**COMMUNITY SERVICES DEPARTMENT**

August 31, 2021

**Subject: Homestead North at Sterling Ranch Phase I Preliminary Plan, Review #3 (SP-20-008)**

2:\Morley\SR Homestead Filling 3\Drawings\Planning\Develop\Homestead North Phase 1_PP.dwg [Sheet 6] 8/2/2021 8:42:45 AM biten

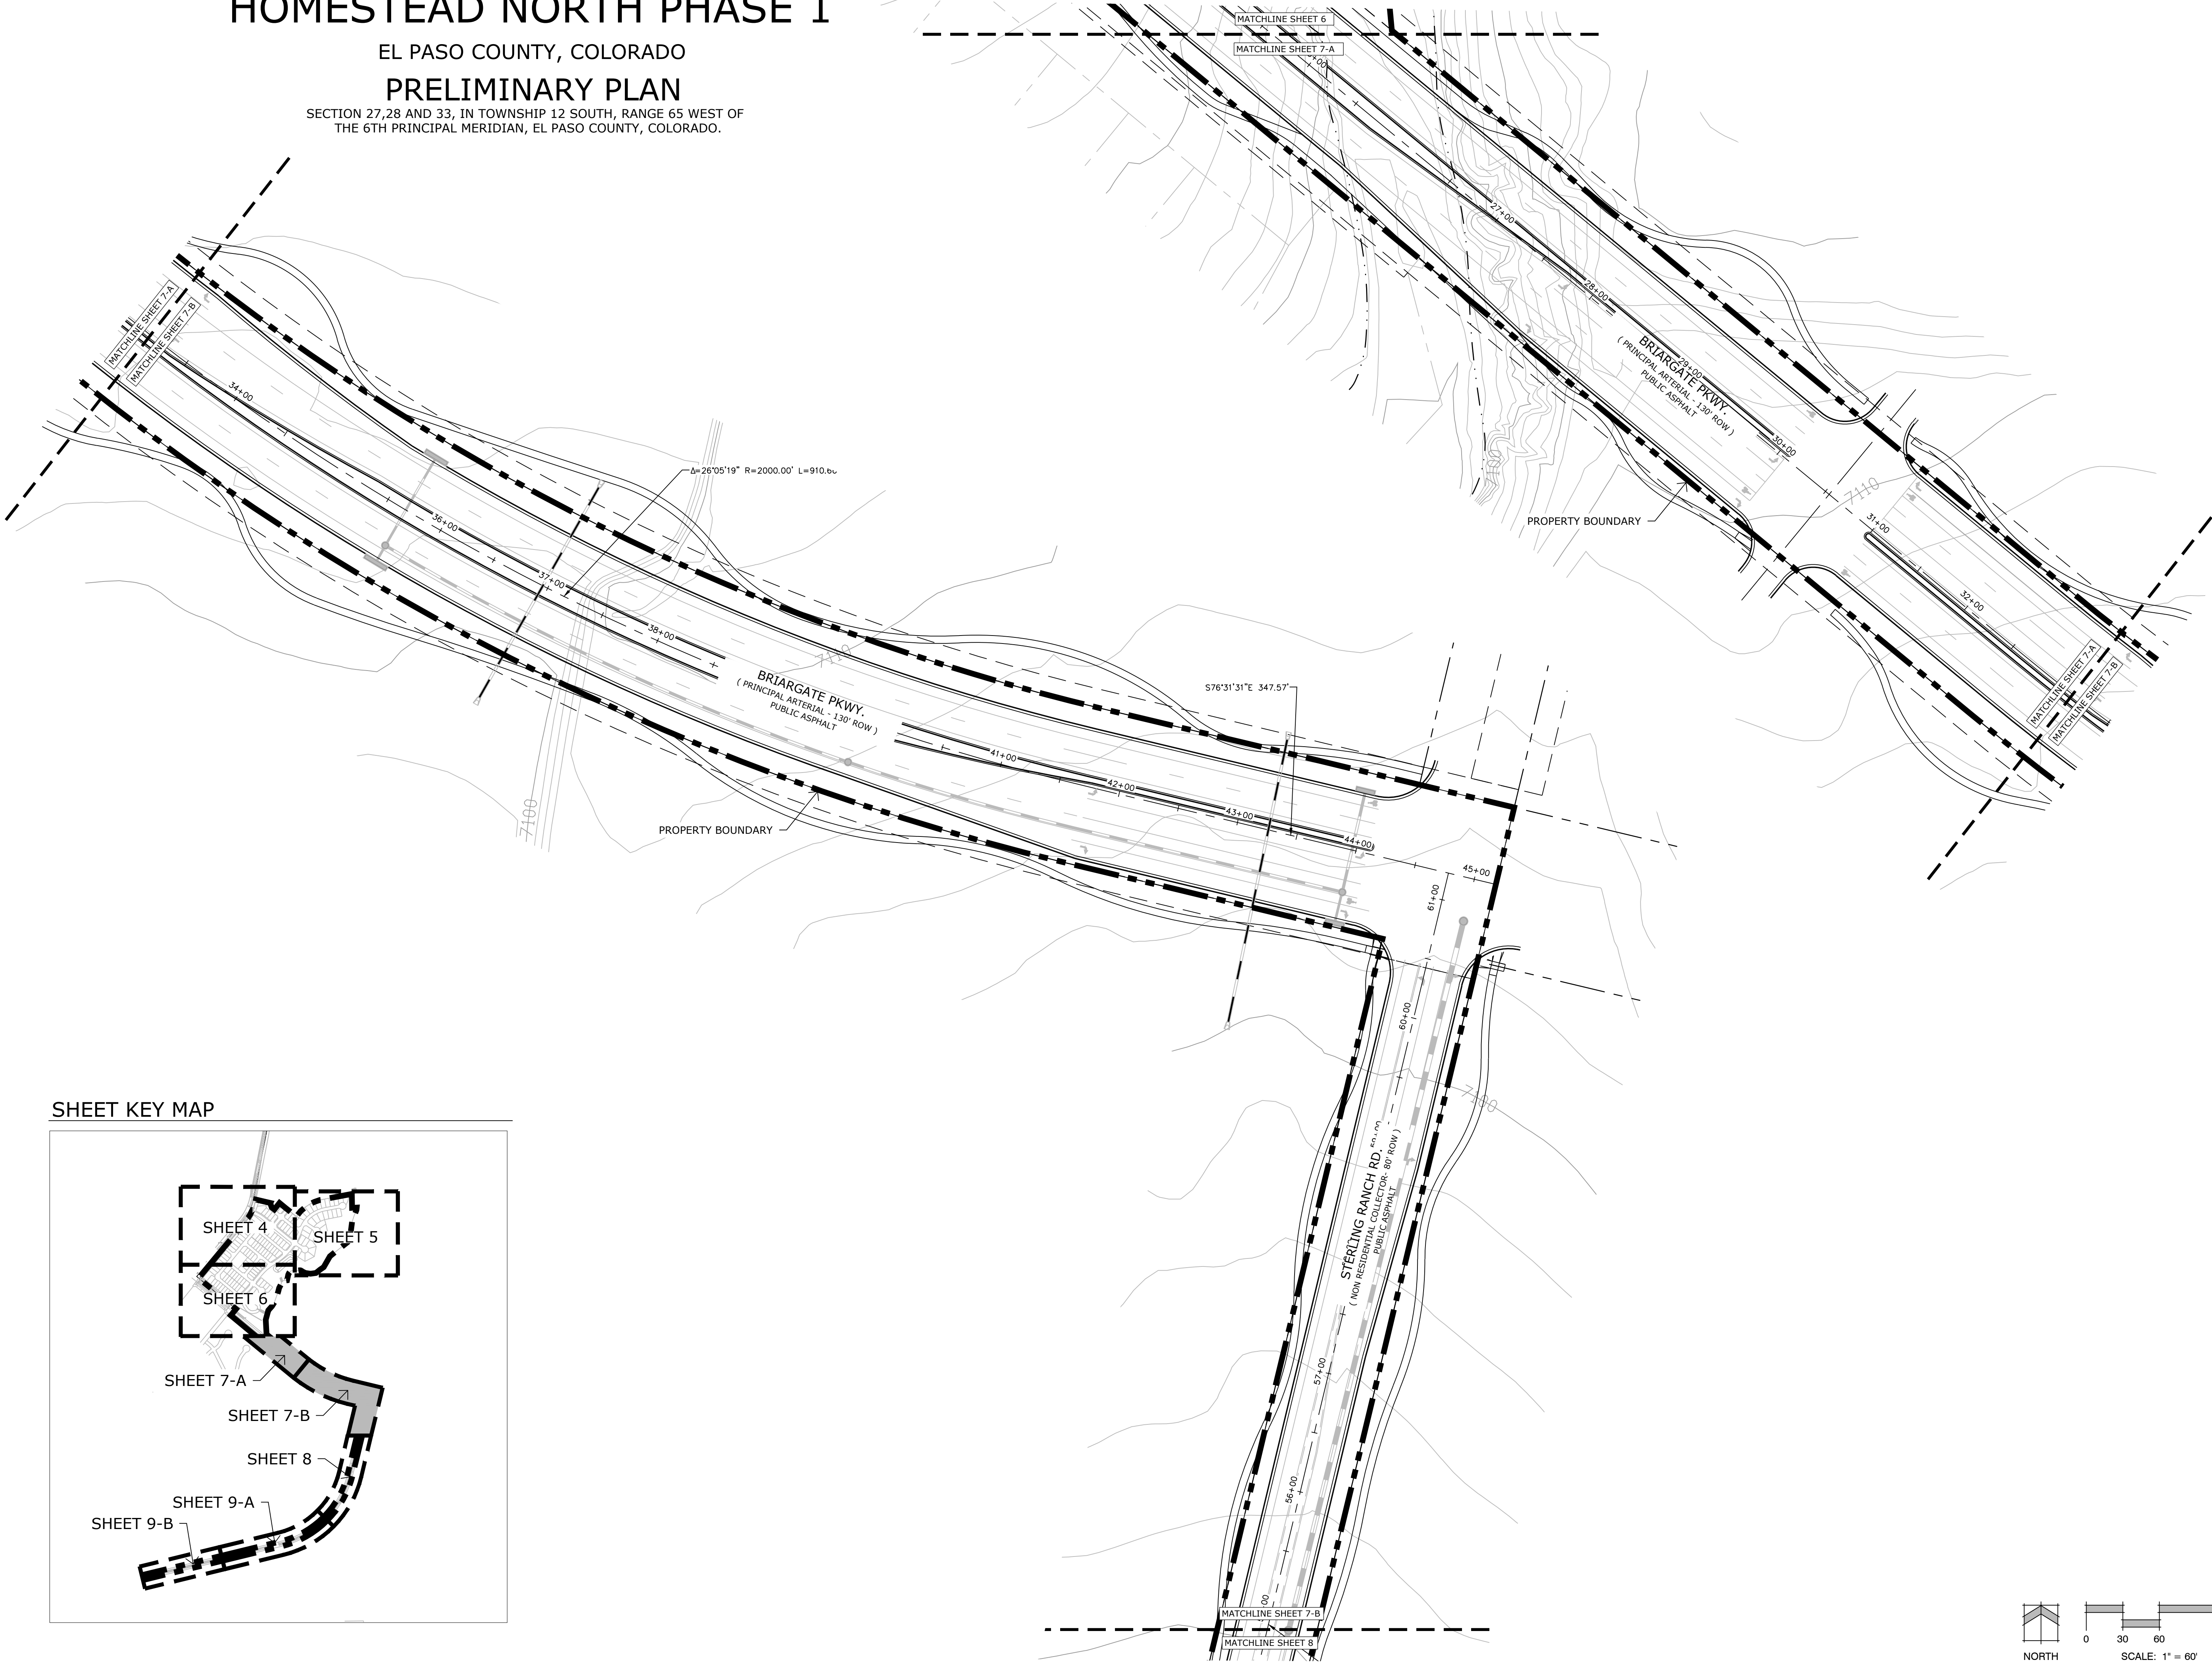
The Park Operations Division of the Community Services Department has reviewed the Homestead North at Sterling Ranch Phase I Preliminary Plan, Review #3, development application and has the following additional comments of behalf of El Paso County Parks. **EPC Parks staff continues to note the absence of the Sand Creek Regional Trail from the Preliminary Plan cover sheet and all additional sheets included with the Preliminary Plan. While a trail or road is shown in the Preliminary Plans, it is labeled as a "15' Maintenance Trail" and does not continue south of Briargate Parkway. The General Notes section does mention that trails labeled as "County Regional Trail" will be maintained by El Paso County, but none exist on this iteration of the Preliminary Plan.**

***"Staff questions the removal of the Sand Creek Regional Trail alignment and labeling from the Preliminary Plan, particularly on the cover page and Site Plans. The included utility and grading plans do show what appears to be the Sand Creek Regional Trail, but there are no labels indicating it as so. As noted in the following comments and recommendations, as endorsed by the Park Advisory Board on January 13, 2021, EPC Parks is requesting a 25' trail easement for the construction and maintenance of the Sand Creek Regional Trail. Staff also requests clarification as to the number of neighborhood parks proposed for Homestead North. The current Letter of Intent mentions one 0.87-acre park located in Tract B, but also indicates a park in Tract F. The location of the Tract F park is not indicated in the Preliminary Plan. Furthermore, staff acknowledges the increase in Preliminary Plan acreage from 60.6 acres to 77.7 acres due to the inclusion of the eastern and southern extensions of Briargate Parkway and Sterling Ranch Road, respectively."***

*Due to the location of the Sand Creek Primary Regional Trail within the Homestead North at Sterling Ranch Phase I development, El Paso County Parks staff recommends that the applicant designate, provide, and dedicate to El Paso County a 25-foot trail easement that allows for the construction, maintenance, and public access of the regional trail. Furthermore, staff recommends fees in lieu of land dedication for regional and urban park purposes.*

*The Park Advisory Board recommends that the Planning Commission and the Board of County Commissioners include the following conditions when considering and/or approving the Homestead North at Sterling Ranch Phase I Preliminary Plan: (1) designate and provide to El Paso County a 25-foot trail easement through Homestead North at Sterling Ranch, within Tract F, that allows for construction, maintenance, and public access of the Sand Creek Primary Regional Trail, and dedicate the easement to El Paso County prior to the recording of the forthcoming final plat(s); 2) include descriptions, drawings, and locations of the two neighborhood parks in the Letter of Intent and Preliminary Plans, respectively; 3) fees in lieu of land dedication for regional park purposes in the amount of \$68,649 and urban park fees in the amount of \$43,365 will be required upon recording of the forthcoming final plat(s). A Park Lands Agreement may be an acceptable alternative to urban park fees, provided the agreement is approved by the County and executed prior to recording the forthcoming final plat(s).”*
